WEST SUSSEX COUNTY COUNCIL CONSULTATION

TO:	Arun District Council FAO:Mr A Wood
FROM:	WSCC - Highways Authority
DATE:	1 December 2020
LOCATION:	Spindlewood Yapton Lane Walberton BN18 0AS
SUBJECT:	WA/79/20/PL Demolition of existing dwelling & erections of 8 No. new dwellinghouses with associated landscaping & parking (resubmission following WA/30/20/PL). This application is a Departure from the Development Plan & is in CIL Zone 3 and is CIL Liable.
DATE OF SITE VISIT:	n/a
RECOMMENDATION:	No Objection
S106 CONTRIBUTION TOTAL:	n/a / £ See below for breakdown.

Drawing No.
DPA 02

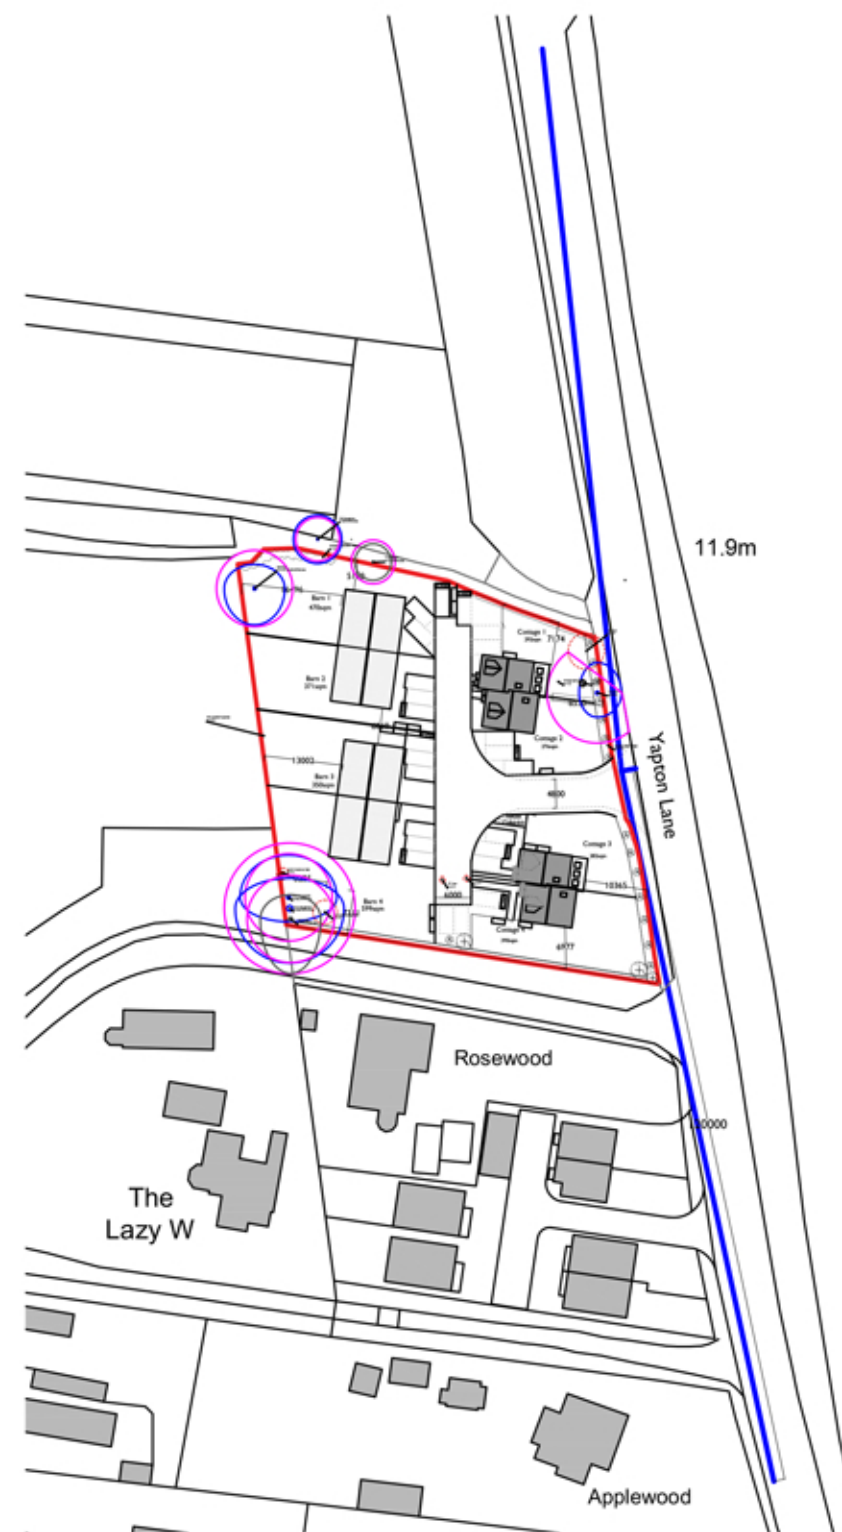
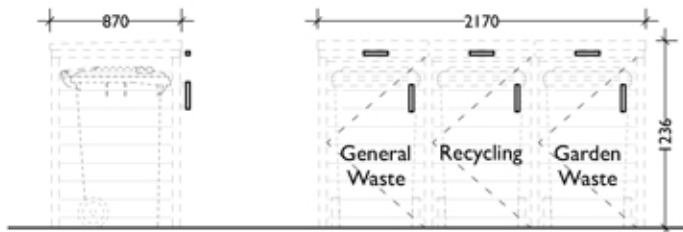
Plan DPA-02 provides evidence of the proposed visibility splays of 2.4m x 120m in both directions, which is in line with DMRB standards for a 40mph road. Visibility from this access provides 120m in both directions set back 2.4m from the access. WSCC are satisfied this access meets the required standards, and a s278 agreement will need to be progressed with the Implementation Team.

The proposed site plan indicates the layout will be shared use, which is acceptable where volumes of motor traffic is below 100 vehicles an hour, and in short lengths, or where they form cul-de-sacs. The site meets both criteria, and as Yapton Lane does not provide footways it would be in keeping with the natural layout of the adjoining road.

Parking provision has been calculated for 24 cars, 3 spaces are located outside each dwelling, all of which have 3 bedrooms. This parking layout has been assessed using the WSCC car parking calculator, using a parking allocation of 2 spaces per property. This creates a parking demand for 24 spaces, assuming the third space will be unallocated. Based on the calculator results WSCC are satisfied the development provides enough parking for the proposed development.
